KITITAS COUNTY

MEMORANDUM

TO: All Staff
FROM: Public Works Plan Review Team
DATE: December 08, 2025
SUBJECT: BL-25-00022 Bonafair-Bugni

Previous Survey

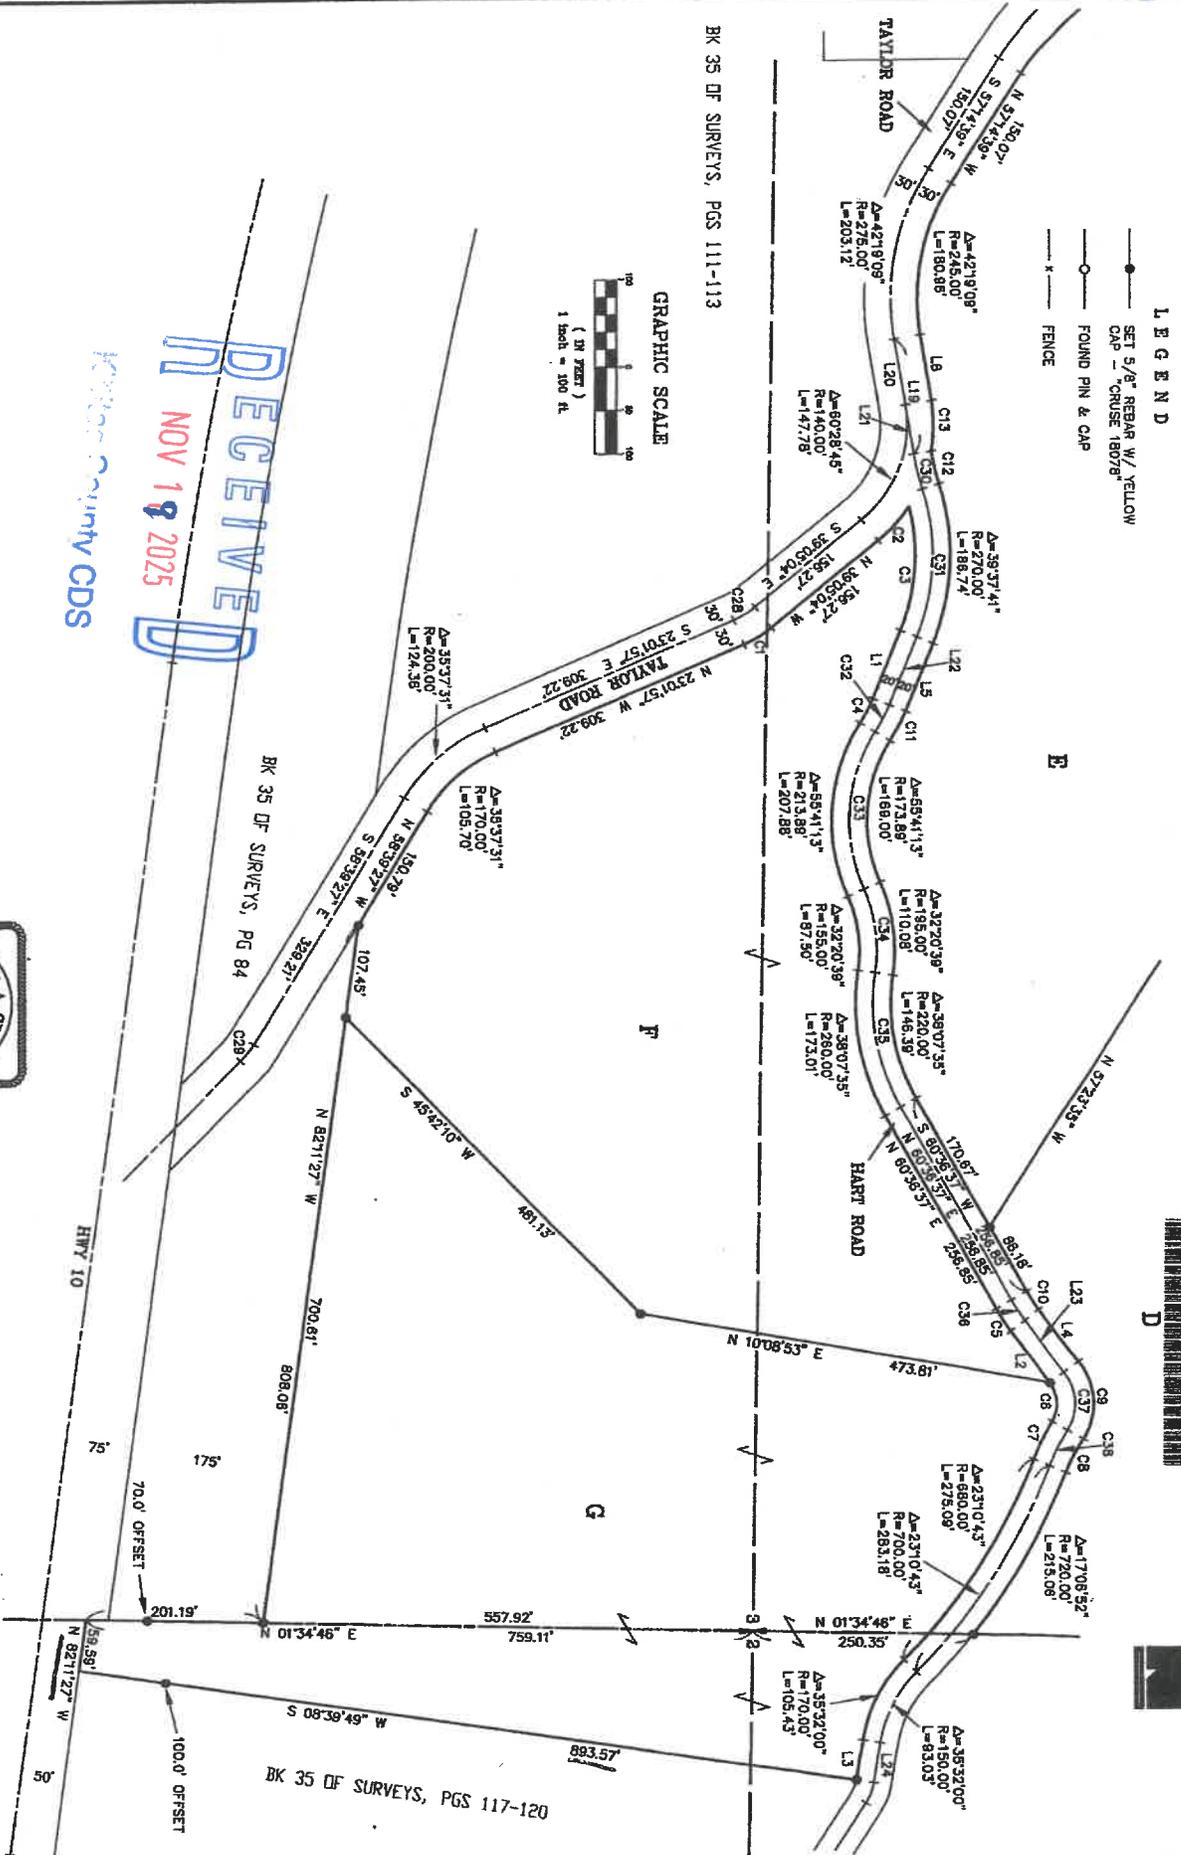
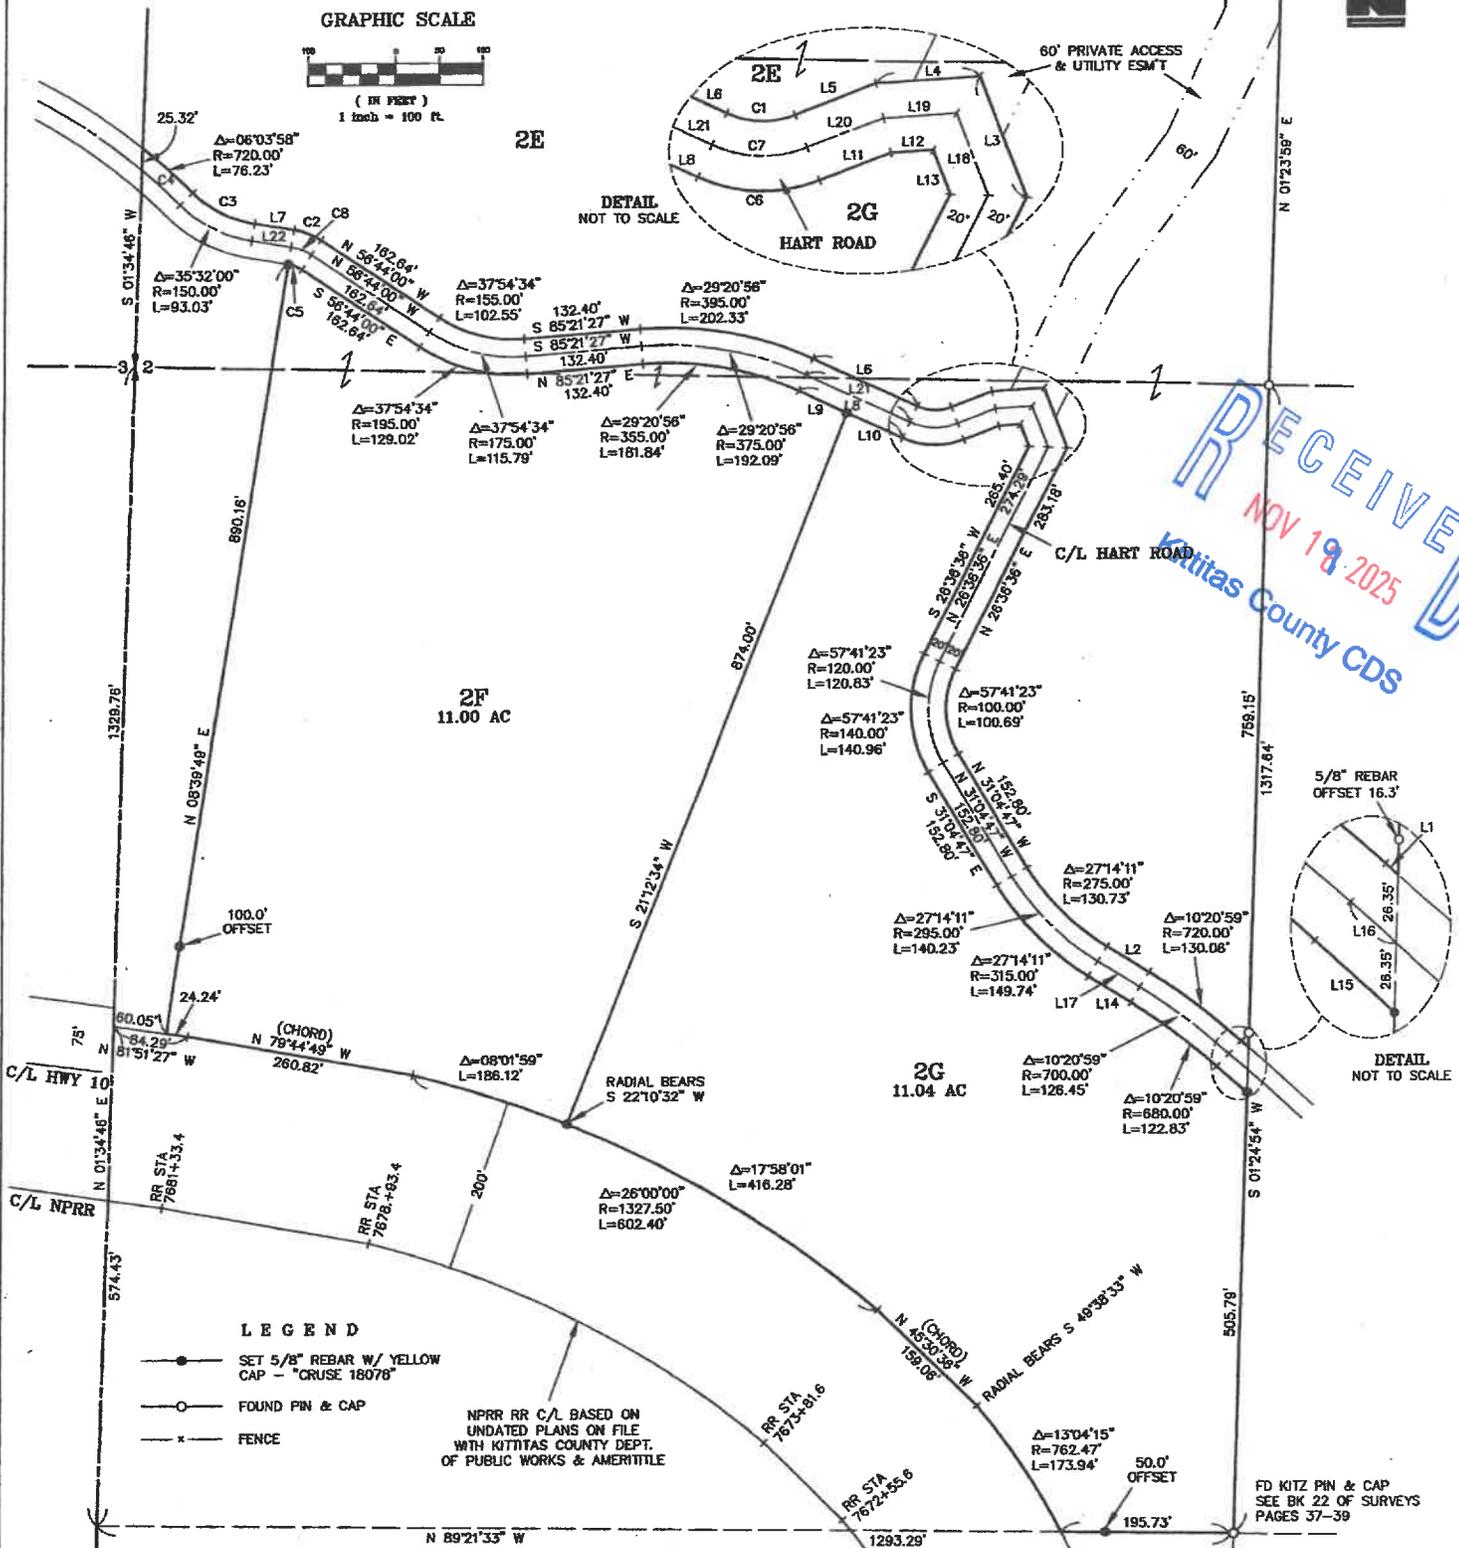
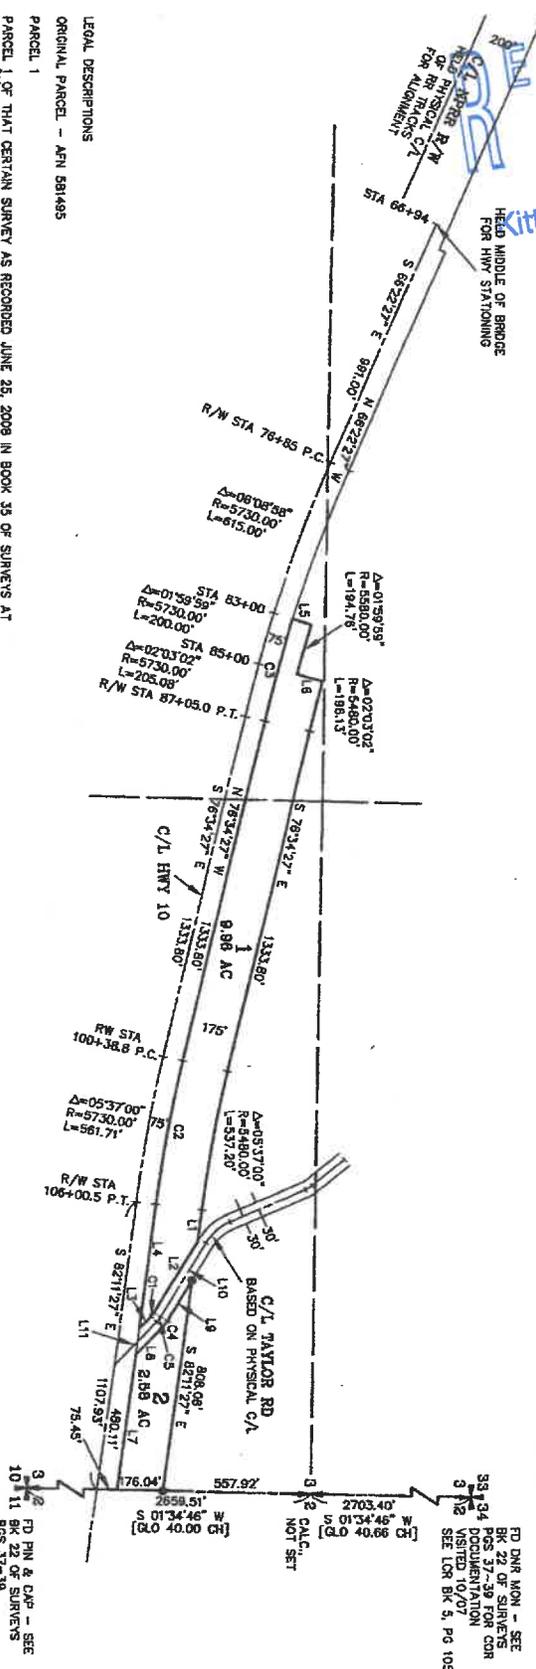
| SURVEY | <p>The final submittal must address the following elements of the survey map:</p> <ol style="list-style-type: none"> 1. Please identify ownership and surfacing for Hart Rd, Taylor Rd and Highway 10. 2. Please label the line of Hwy 10 (Lw Line? Center line?) 3. The south line of Parcel B4 includes a line labeled "(Chord)". This should be clarified. Is this the chord of a spiral offset or a circular curve. It should be clear that the arc is the boundary of the parcel and the chord line isn't. If there are particular complexities about this line and the record information it was derived from, it could be addressed via a note. (JT) <p>OF NOTE Lot closures have not been reviewed at this time.</p> |
